From: Pierre Langlois [REDACTED]
Sent: 29 April 2020 11:15
To: Simon Davis <Simon.Davis@arun.gov.uk>
Cc: Nick Riches [REDACTED]
Subject: RE: AW/237/19/PL The Former Ship Inn, Aldwick

Many thanks for the documents which I have been able to review and provide some comments for you, attached. Whilst the RSA does not propose anything new to what has already been approved under the original planning approval, the updated tracking does show that an articulated lorry would not be able to use the car park for loading and unloading without over running the northern buildout. We have also noticed that any articulated movements should preferably travel to the site from the west and leave from the east to avoid over running the northern build out. This should be reflected in the delivery management schedule. Clarification should be sought over whether the existing bollards in the highway will remain, as it is not clear where these are in relation to the tracked vehicle.

Title
Site Location Plan with Vehicle Tracking : Articulated Vehicle

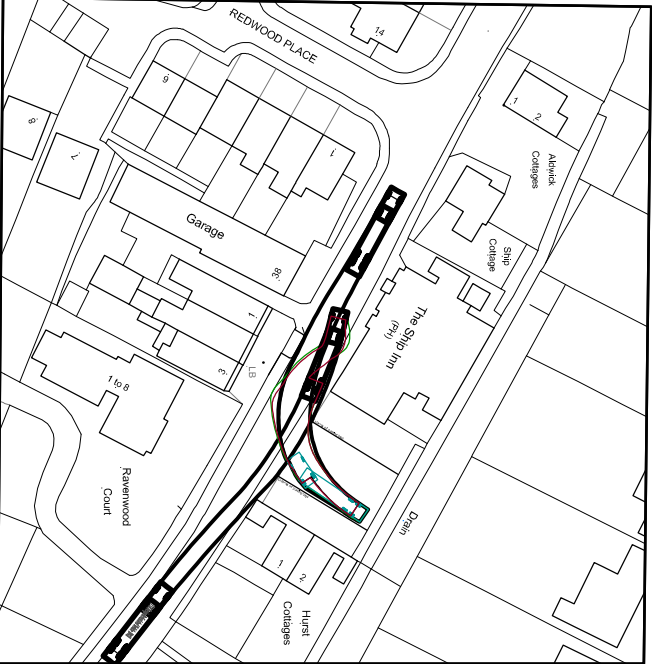
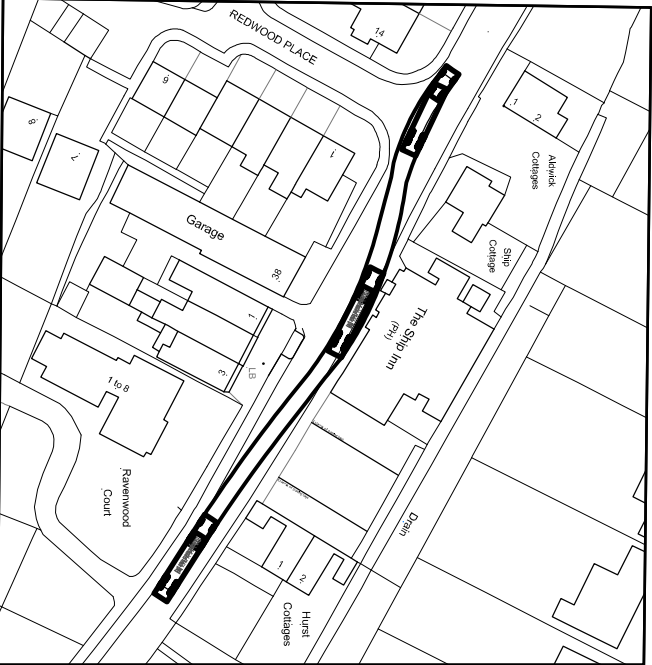
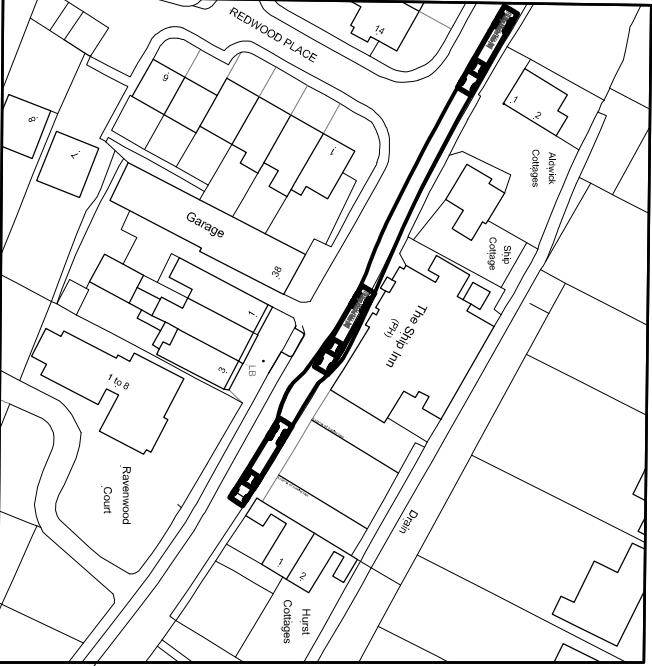
I now have our Highways comments. Just one thing, can you comment on the point she raises in her email below about the bollards.

With regard to the bollards, it is correct to note that the positioning of the bollards at the boundary to the highway is very close to the edge of the tracked vehicle diagrams. Whilst they are very close, they could be negotiated with them remaining insitu, however, it may be more practicable for the ease of delivery vehicles to have them removed and replaced with highway delineation blocks/markers. These would be a granite set or similar set flush or just slightly proud of the roadway surface, at the preference of your highway officer. It would also follow the theme of the delineation markers that are proposed to the s.278 build-out proposals. My client is willing to make these alterations along the property/highway boundary line, subject to agreement with WSCC.
